CITY OF ALBUQUERQUE

February 12, 2019

RE: **Lot 1 Block 9 SAD 228**
6601 Petirrojo NW
Volcano Cliffs Subdivision
Grading and Drainage Plan
Engineers Stamp Date 2/6/19 (D10D00311)

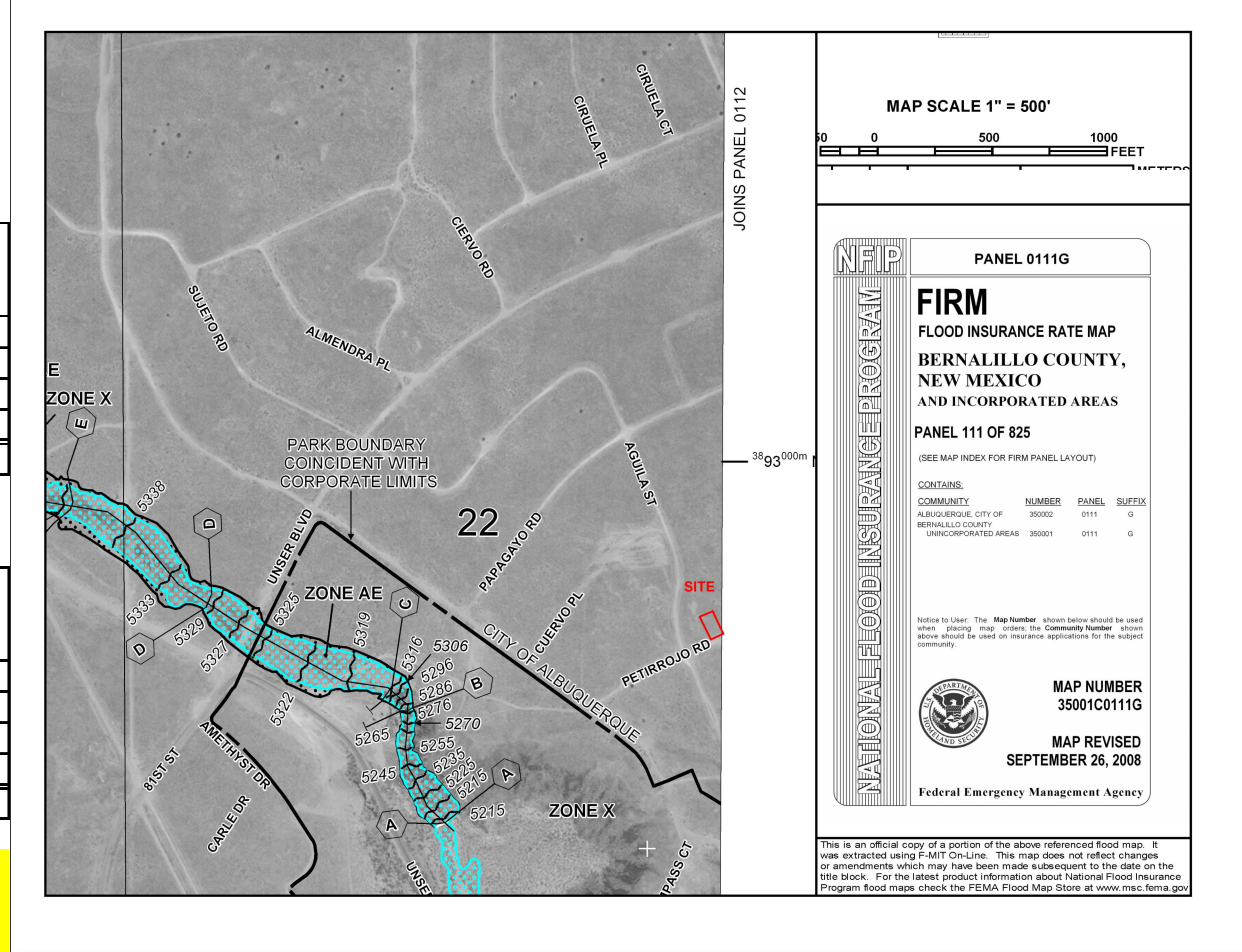
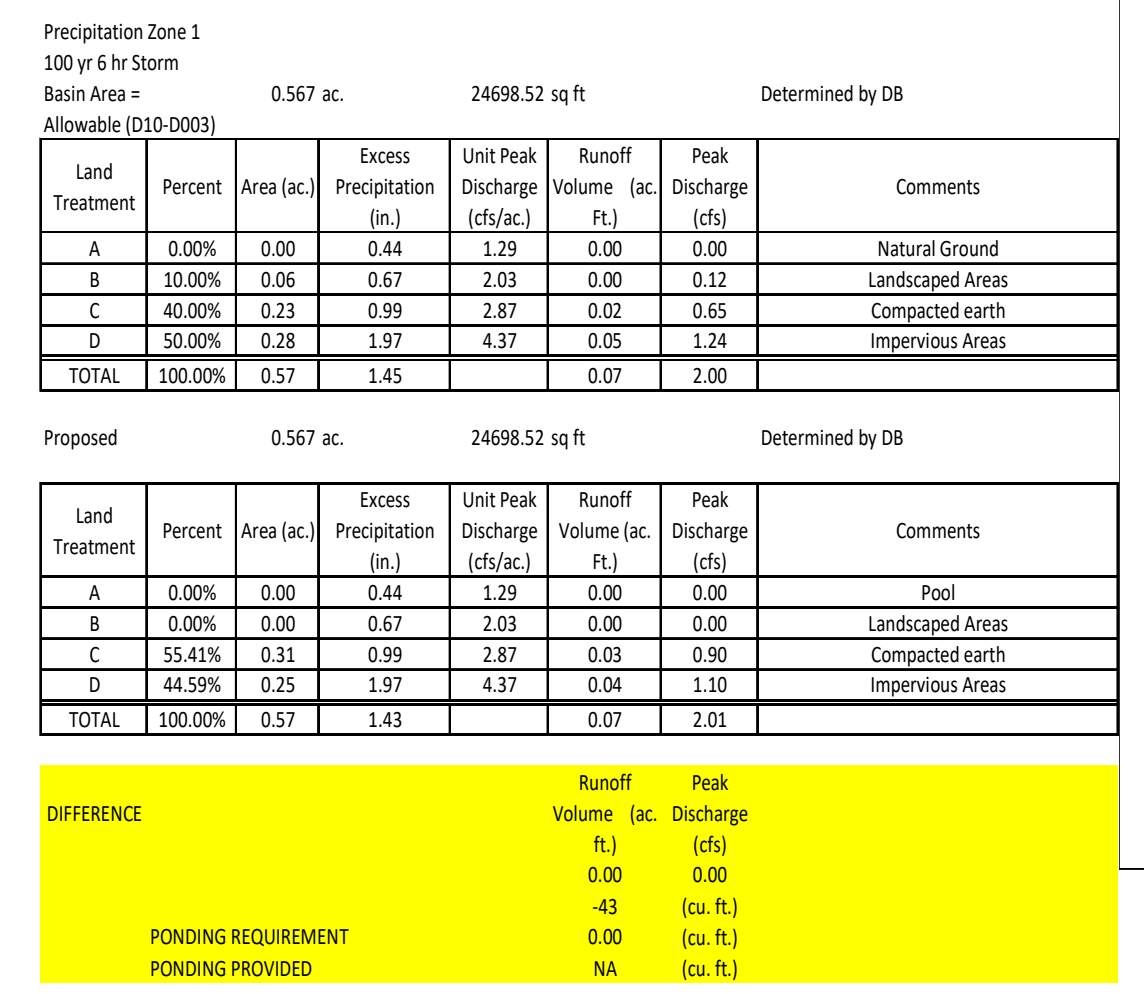
- Show the 7' PUE in the east side yard.
- Provide a cross section of the New CMU wall. Show the CMU wall and the orientation with the property line. If footing protrudes into adjacent property provide a letter of approval from the property owner that allows digging on their property.

- Provide a plan showing that a retaining wall is required or show how the property on the west side will be protected from erosion. If wall is being designed by others provide a statement stating so and a statement stating that this is the plan to be used for said wall and a separate permit is required for the new CMU wall.

- Provide a comment stating that a Pad Certification is required before building permit is approved.
- Provide a comment stating that a final inspection by Hydrology is required before a Certificate of Occupancy is released.

- Provide a table showing the percentages of land treatments A, B, C and D.
